CITY OF ALBUQUERQUE

RE: COA Eagle Rock Transfer Station (C18D084)
Grading Plan, Engineer's Stamp Date: 6-22-2016

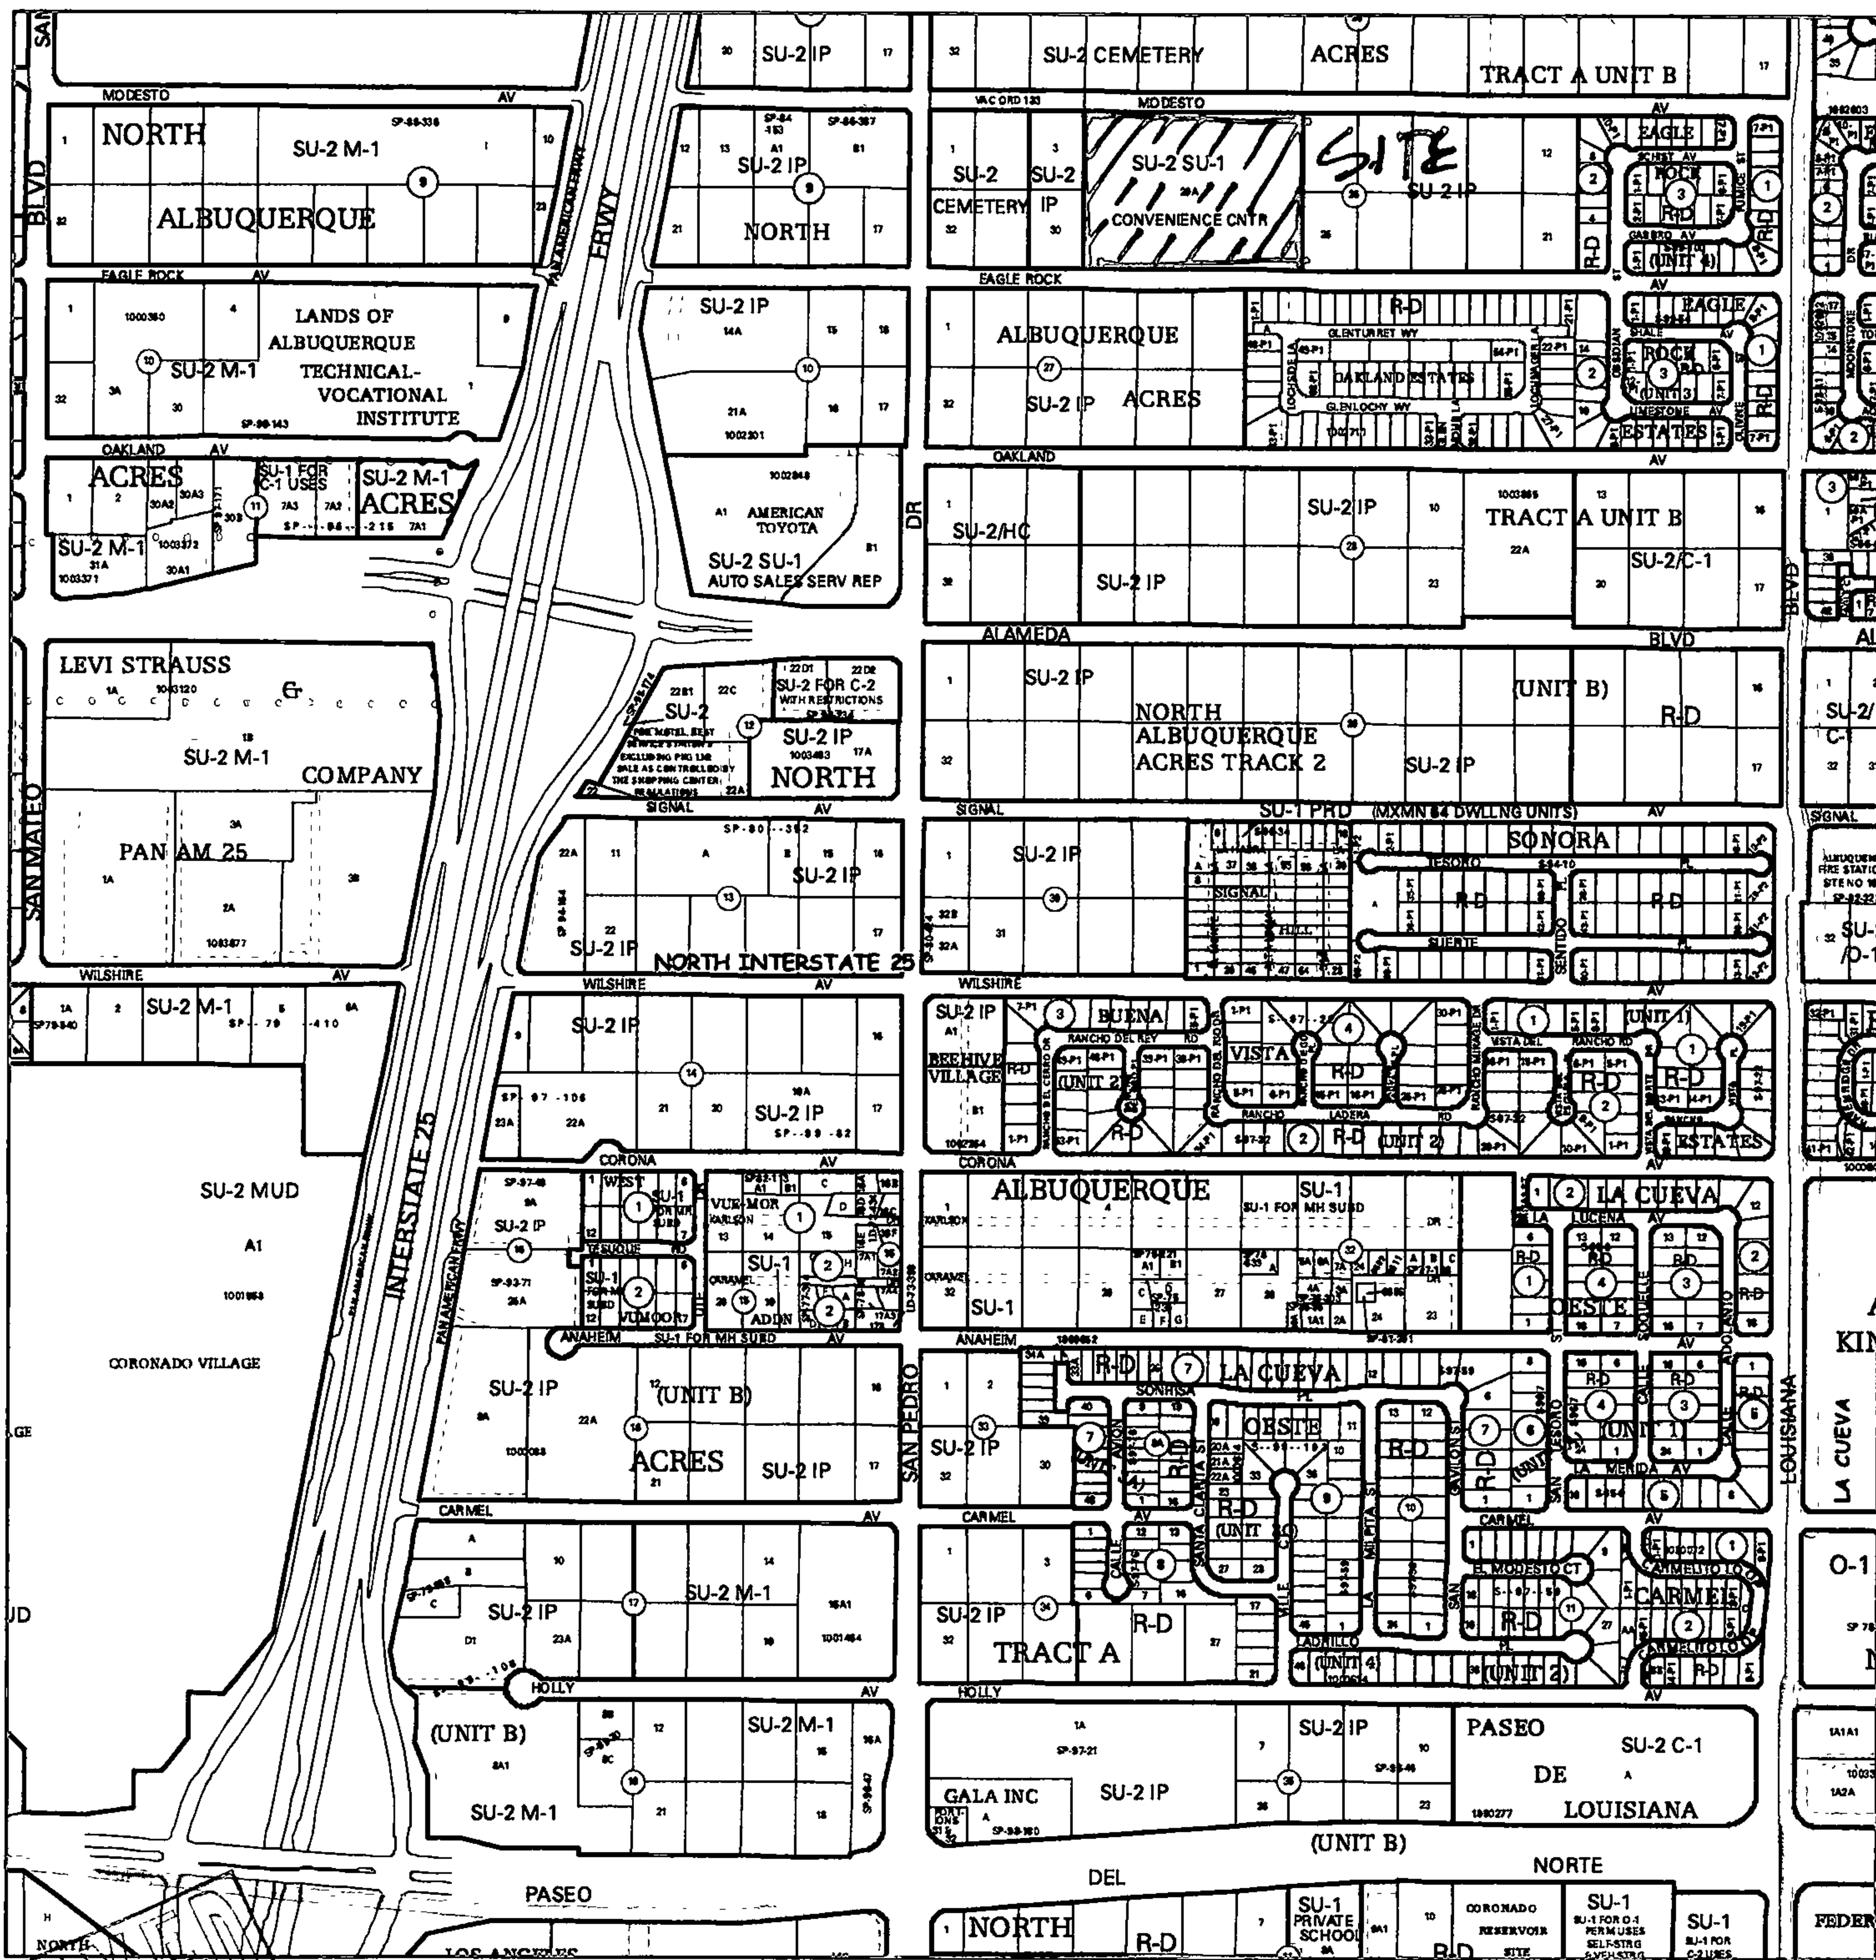
- Label the new contour at the bottom of the pond and put with end points as is done for all the proposed contours.
